Please show 2010 ADA Standards compliance with door, toilet room and fixture clearances.

86 PONDFIELD ROAD WEST, BRONXVILLE, NEW YORK 10708
 DIAMOND COVE GENERAL STORE
 RESTROOM INTERIOR ELEVATIONS AND MOULDING DETAILS
 NASTASI VAIL DESIGN, LLC
 MRS. ALEXANDRA WIGHT
 GENERAL STORE, GREAT DIAMOND ISLAND
 PORTLAND, MAINE 04109

DATE: 1/24/18
 SCALE: 3/4"=1'-0"
 SHEET: 11.5

DATE: 1/24/18
 SCALE: 3/4"=1'-0"
 SHEET: 11.5

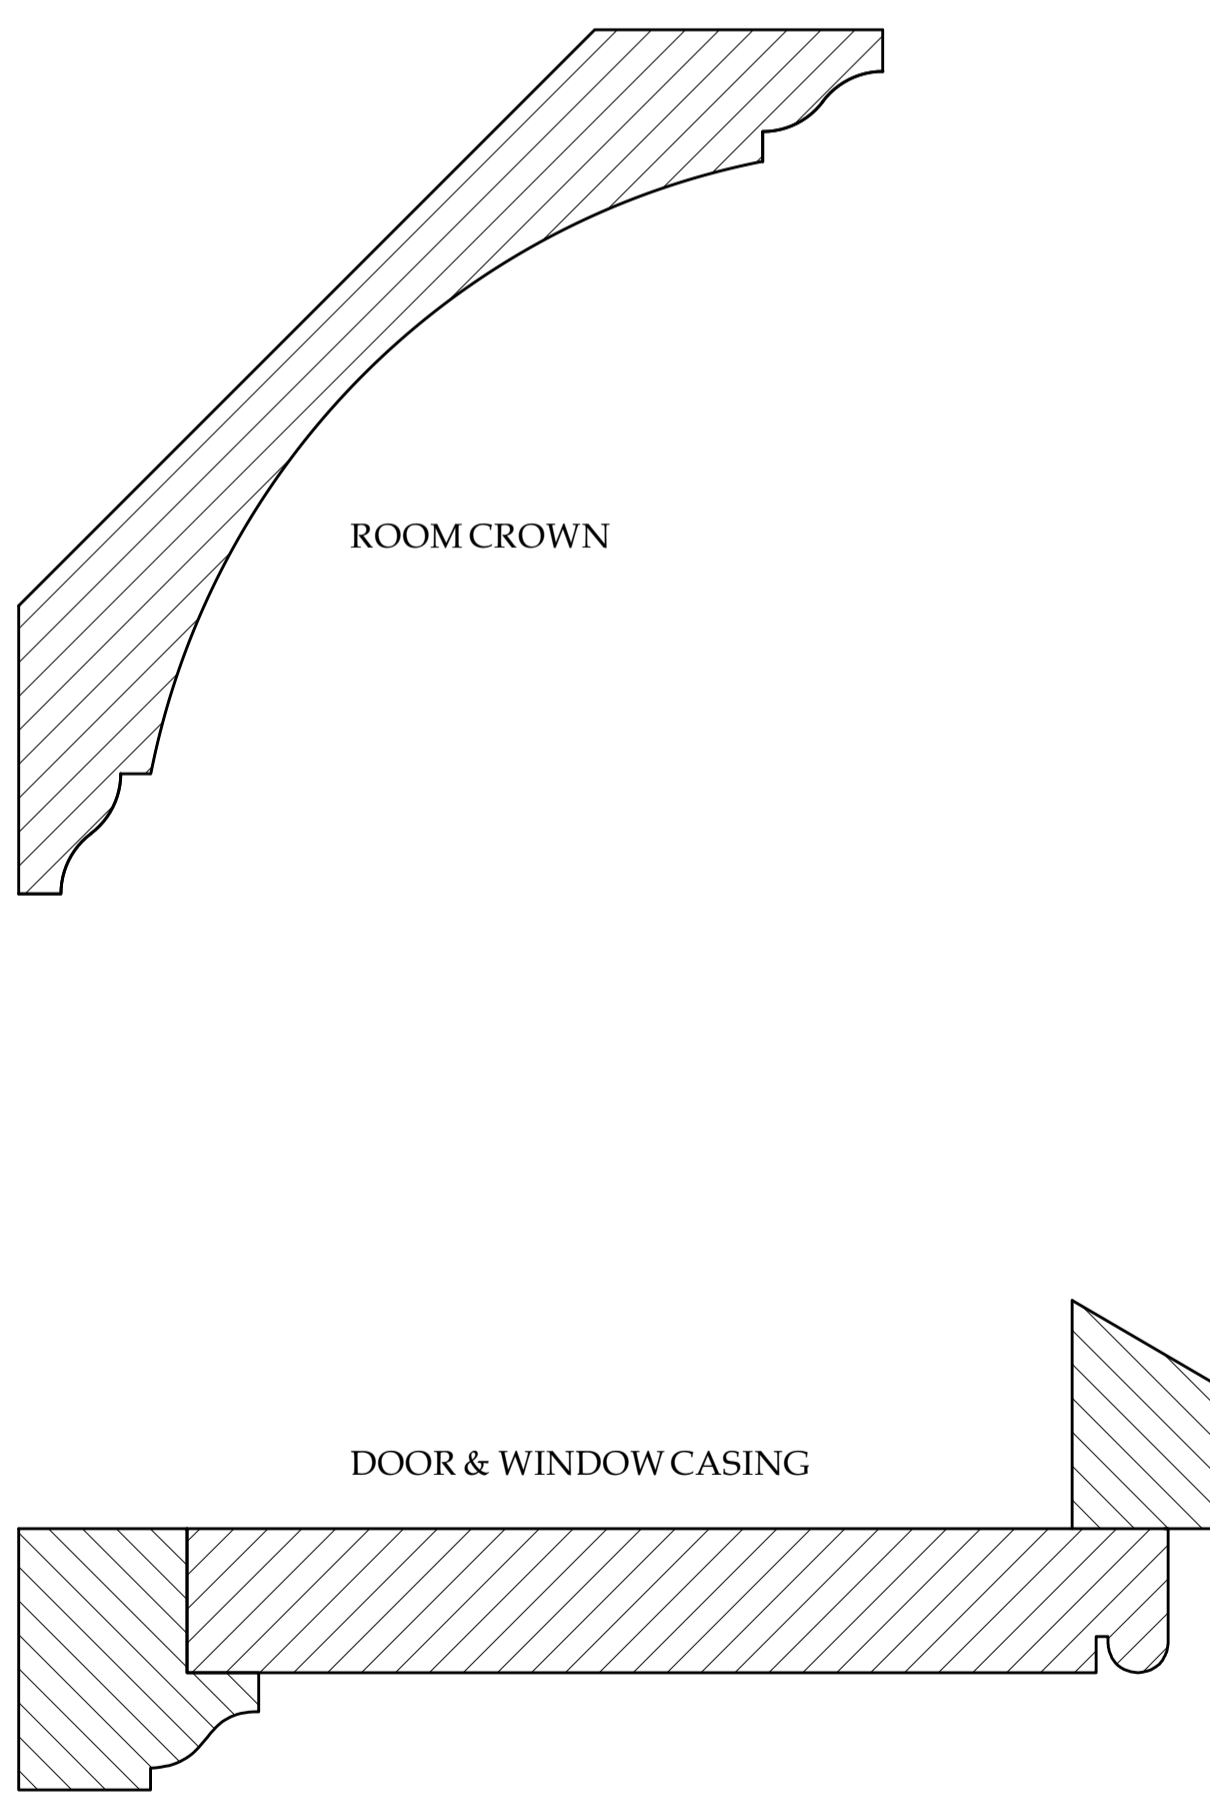
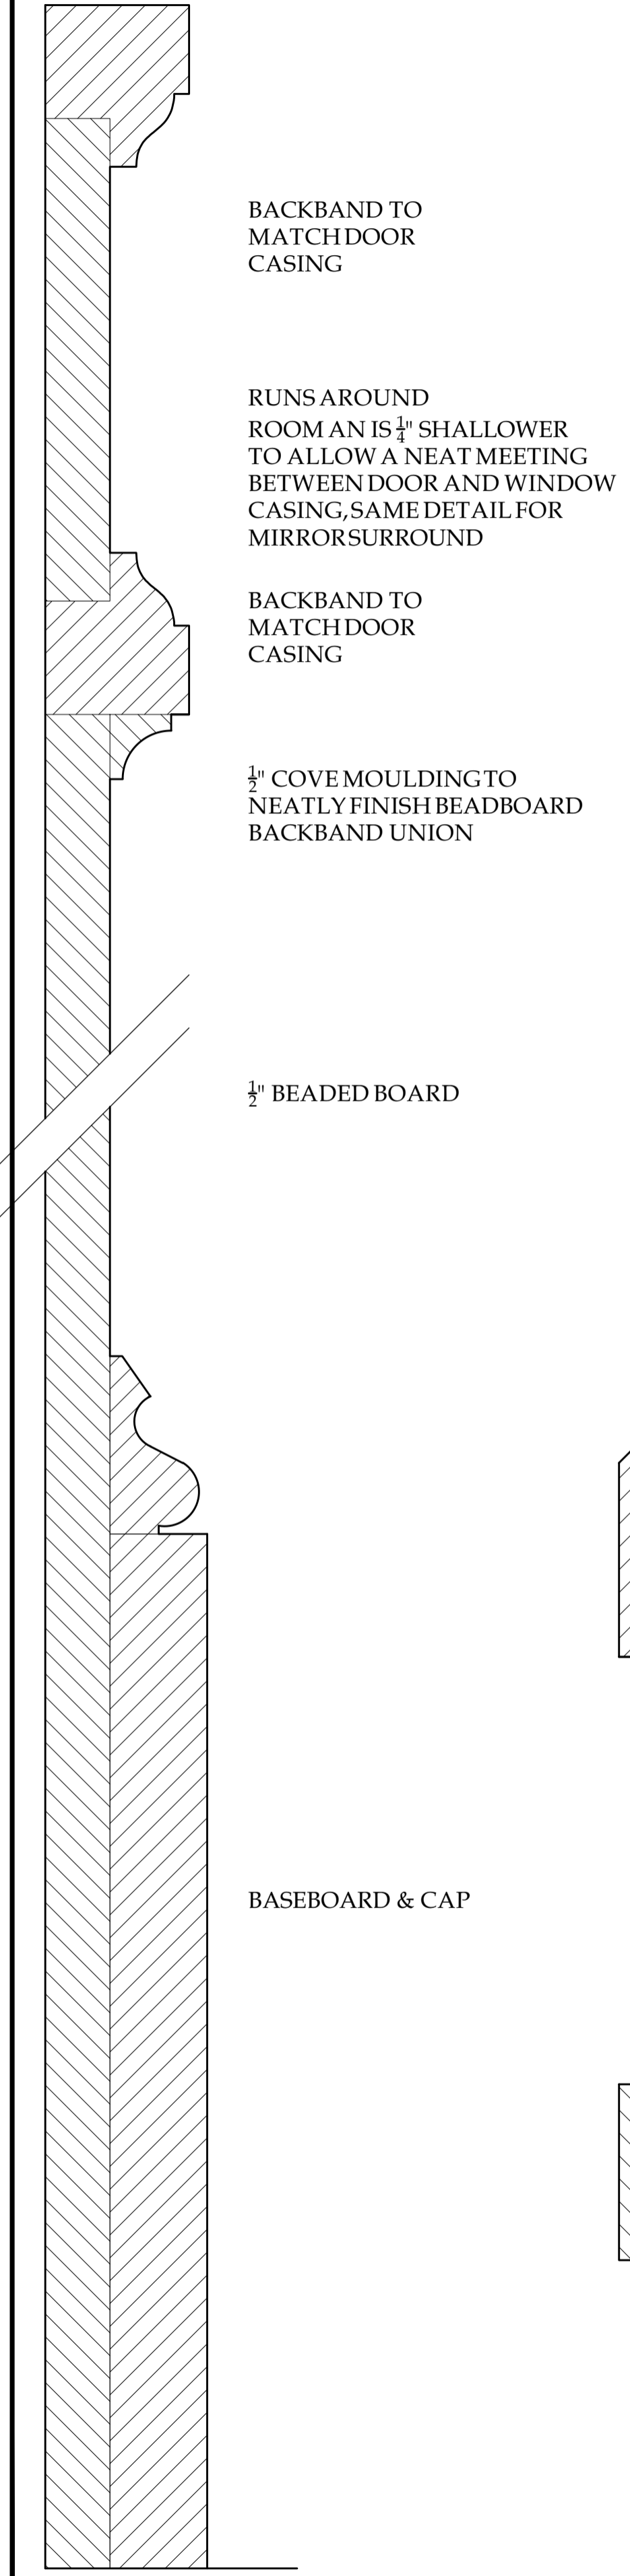
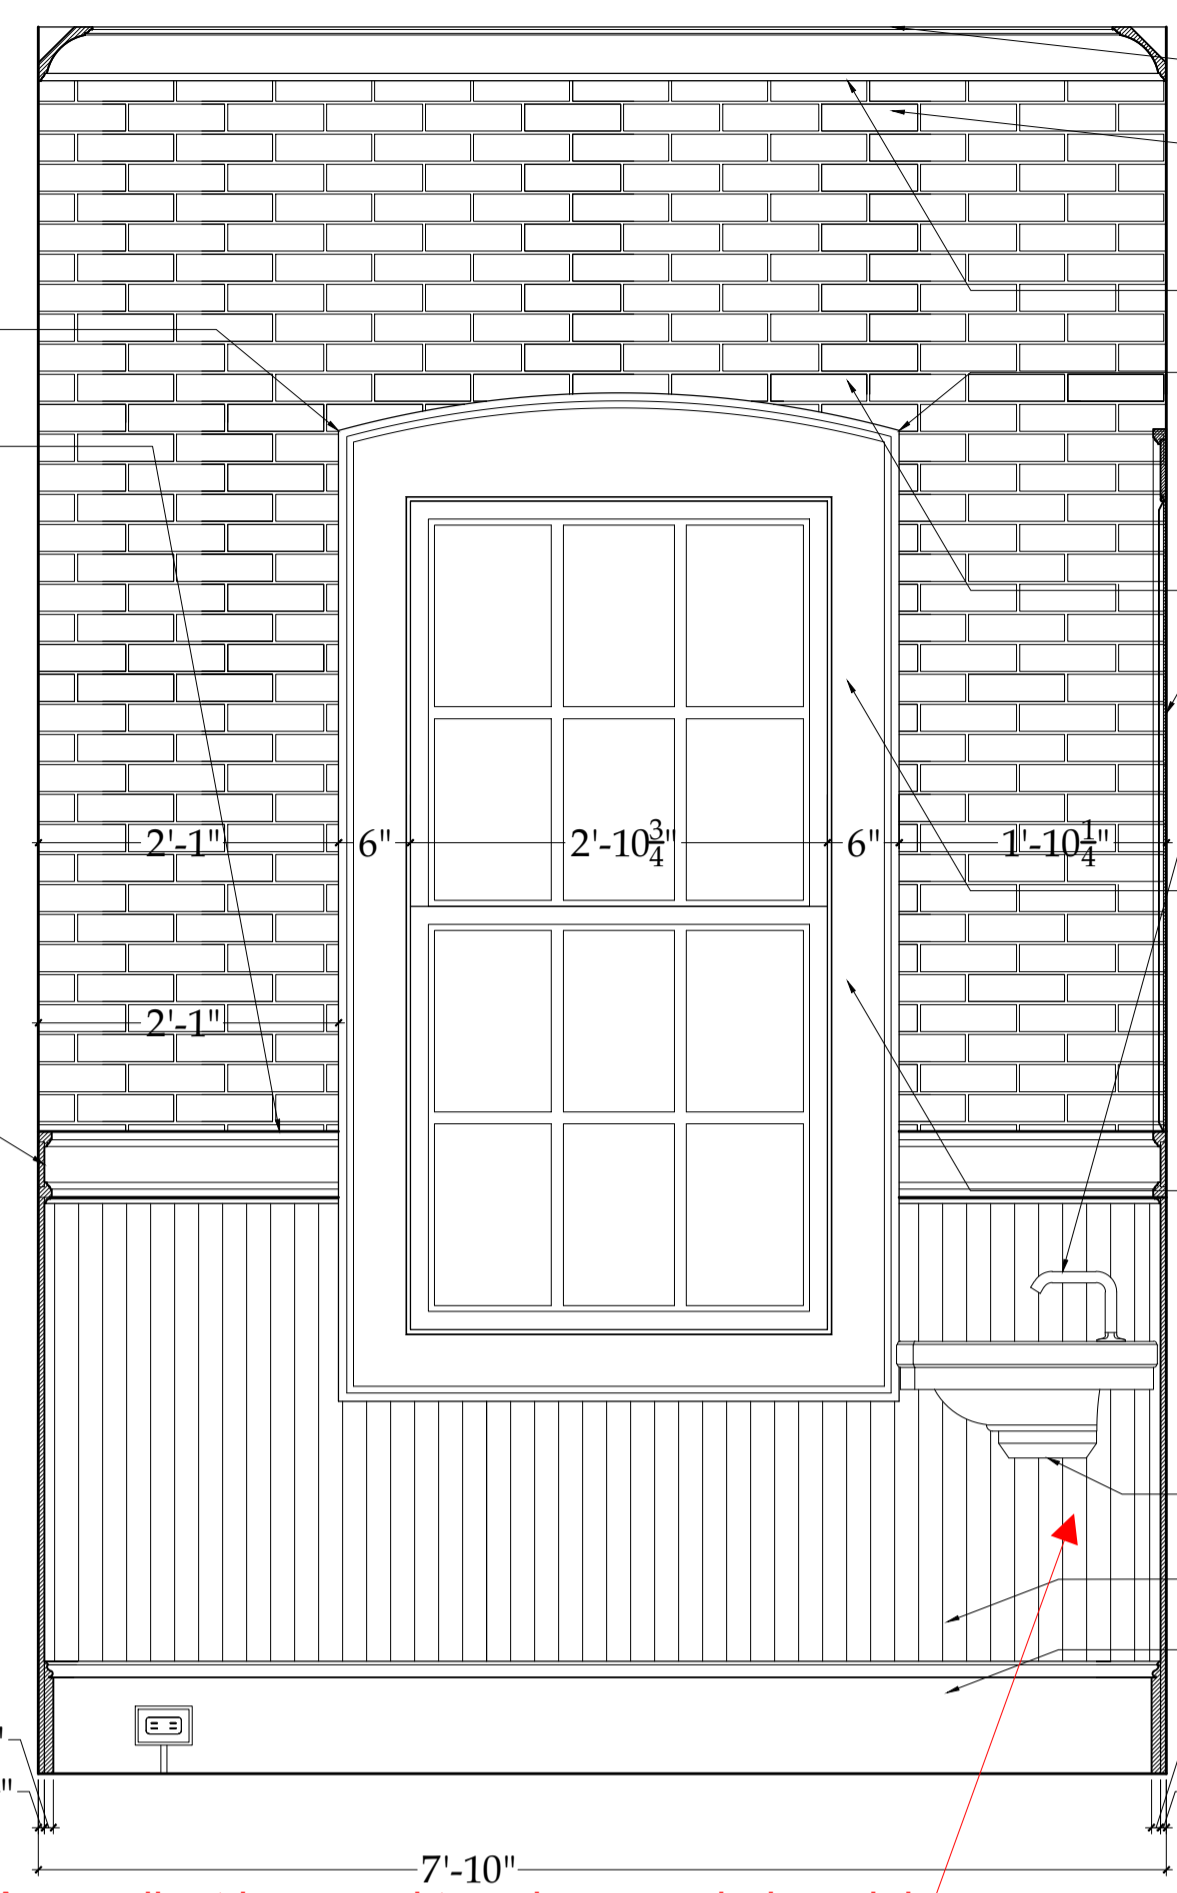
Show ADA compliant knee and toe clearance below sink

Show UPC and ADA compliant distance from wall
